Your Ref: OWPC24103
Our Ref: BE/89/19/PL 31-07-2019
Please ask for:
Maria Tomalova

The change of use of land for the storage of building materials, equipment & plant & for the parking of 2no. articulated vehicles together with part boundary screen fence.

Babsham Business Centre Babsham Lane Bersted

Thank you for your internet representation made on 21st August 2019 which has been recorded as '**an objection**' with the comments as follows:

PROPOSED SITE PLAN - 1:200

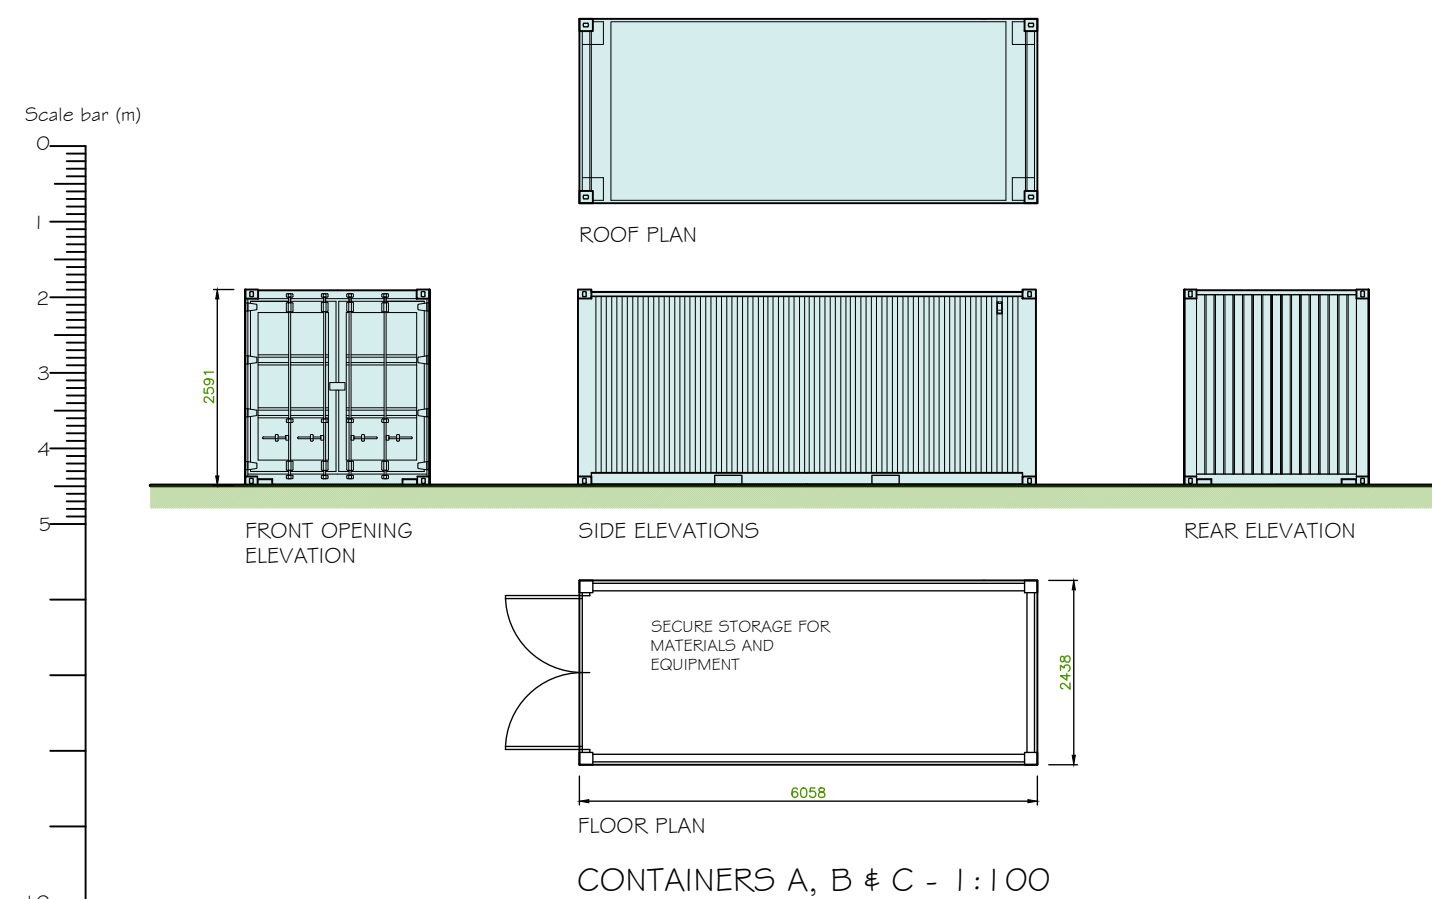
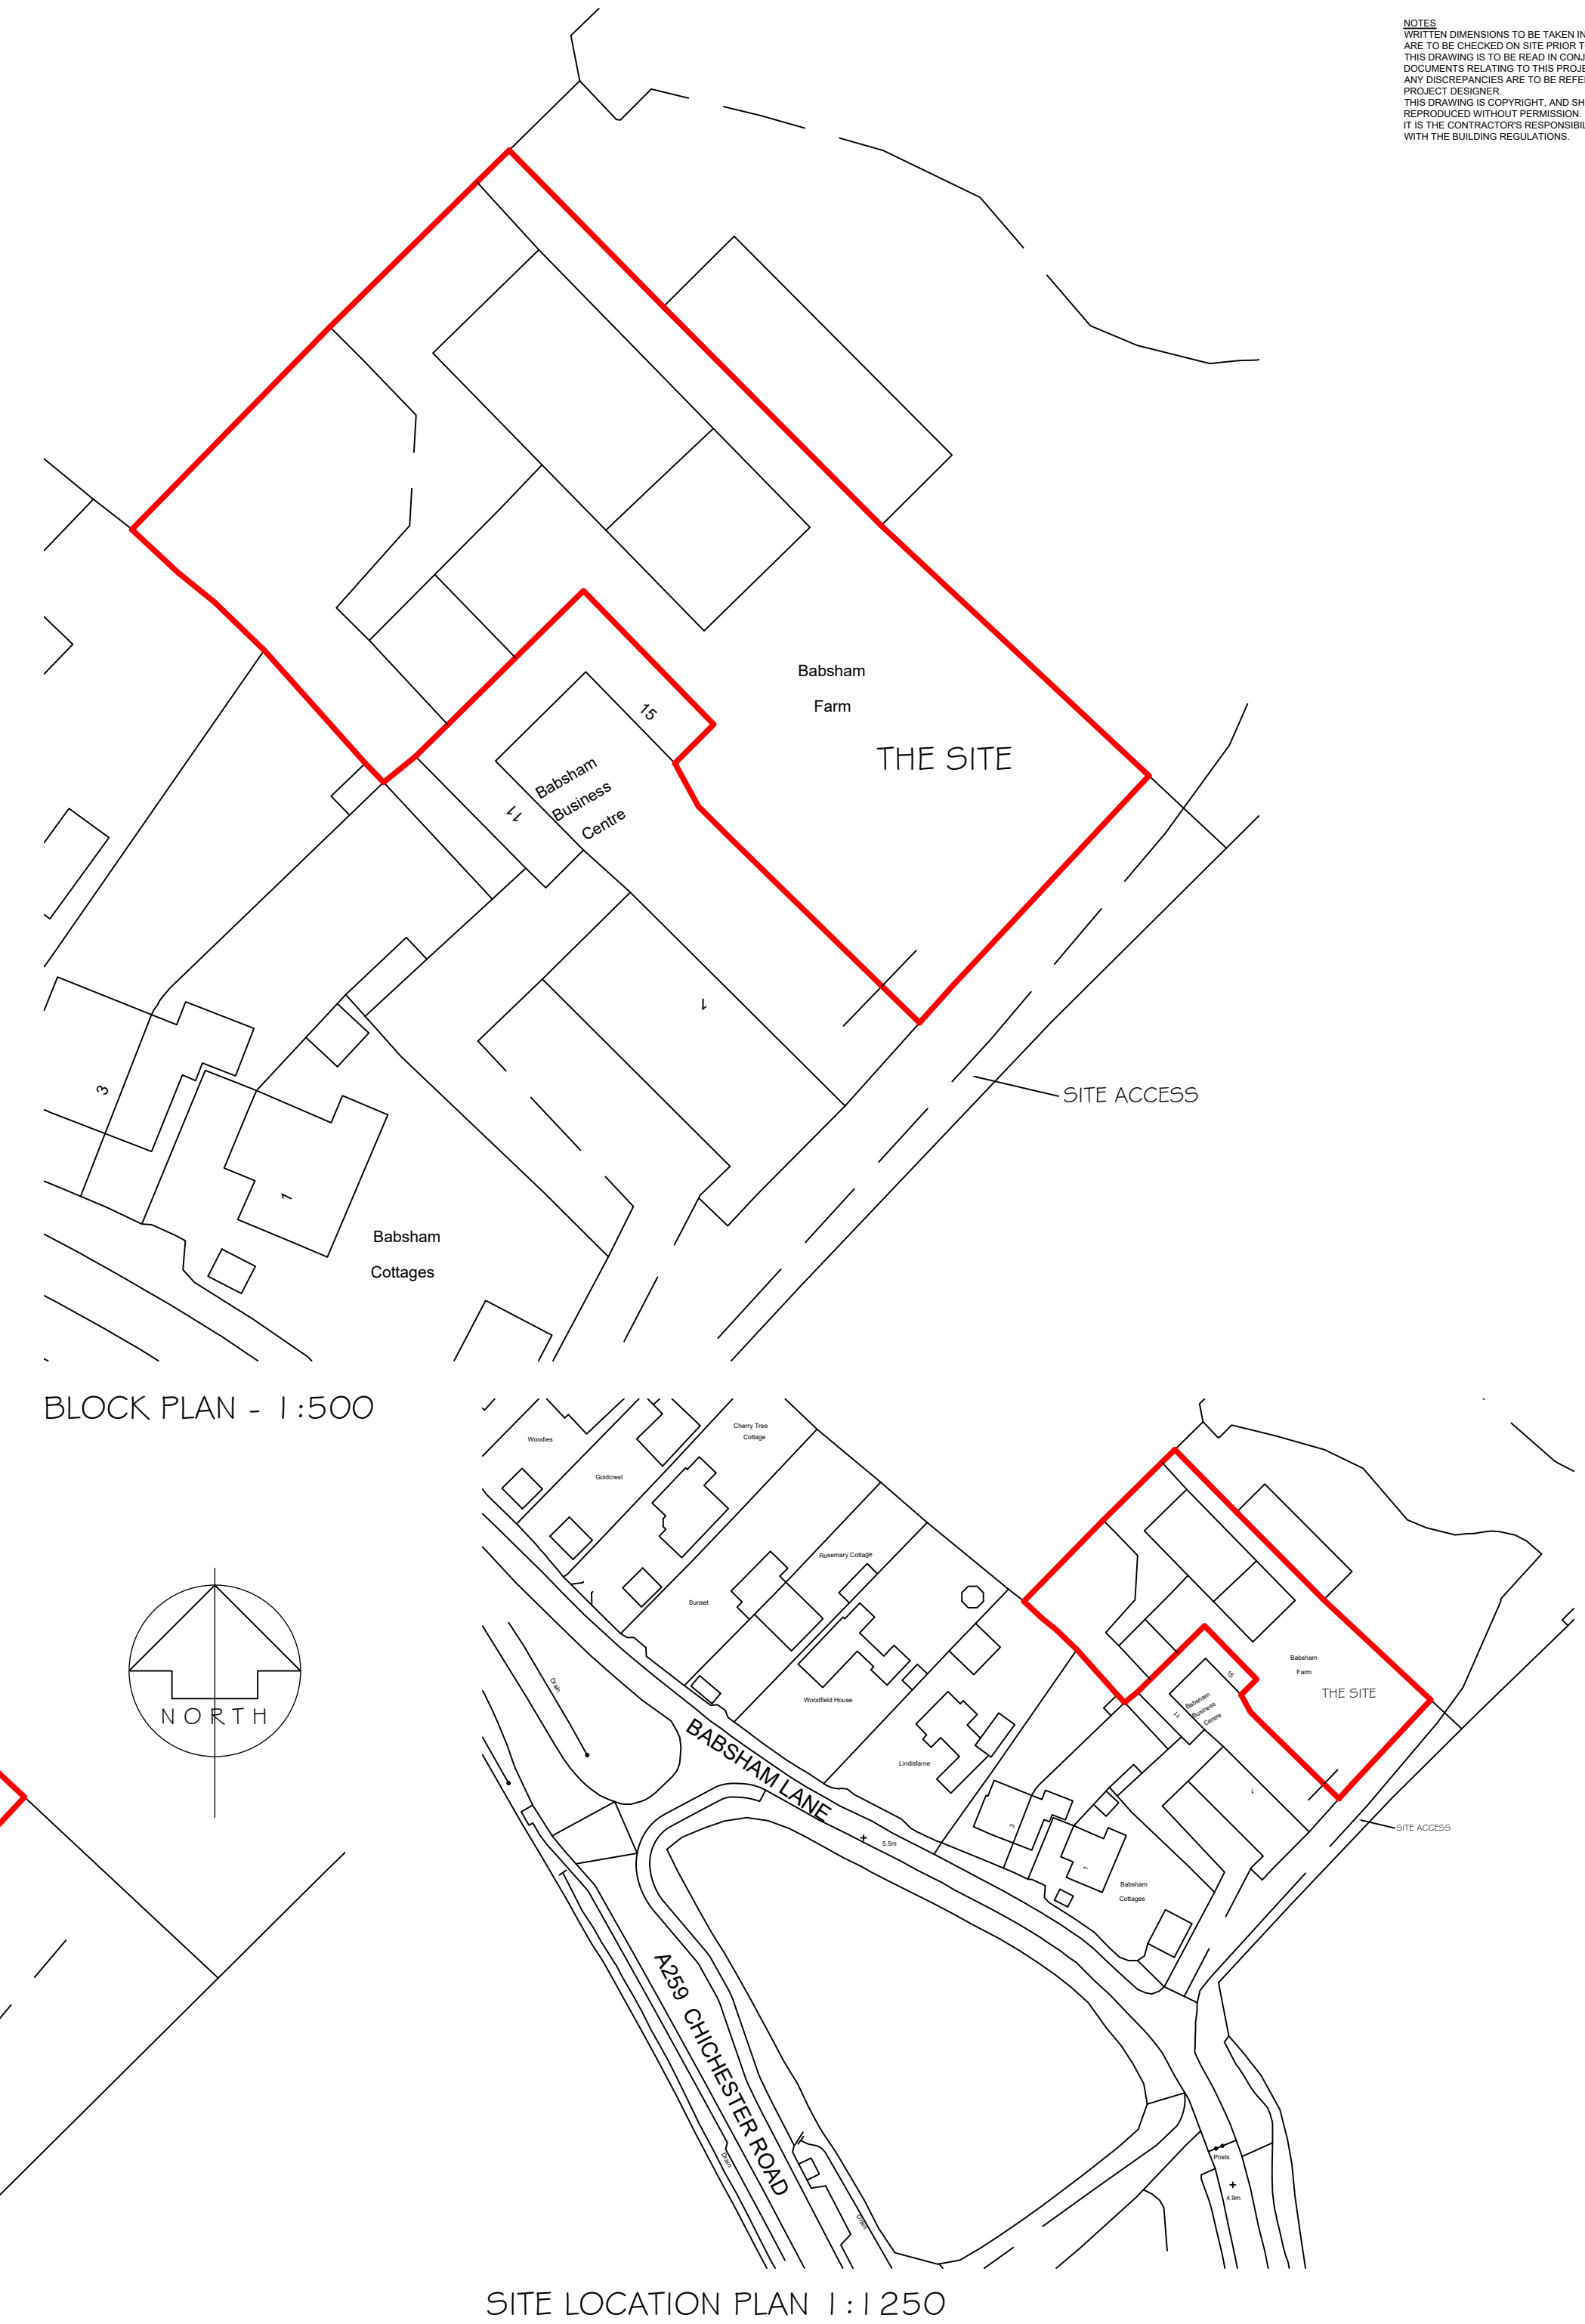
The rubbish is always piling up and is a huge fire risk especially close to a gas supply. I also object to this planning application as the fence that is shown on the plans in red would mean that at the rear of our garden and visible from our upstairs windows would be a fence of more than 7ft! This would seriously affect any privacy that we do have from the upstairs of our property.
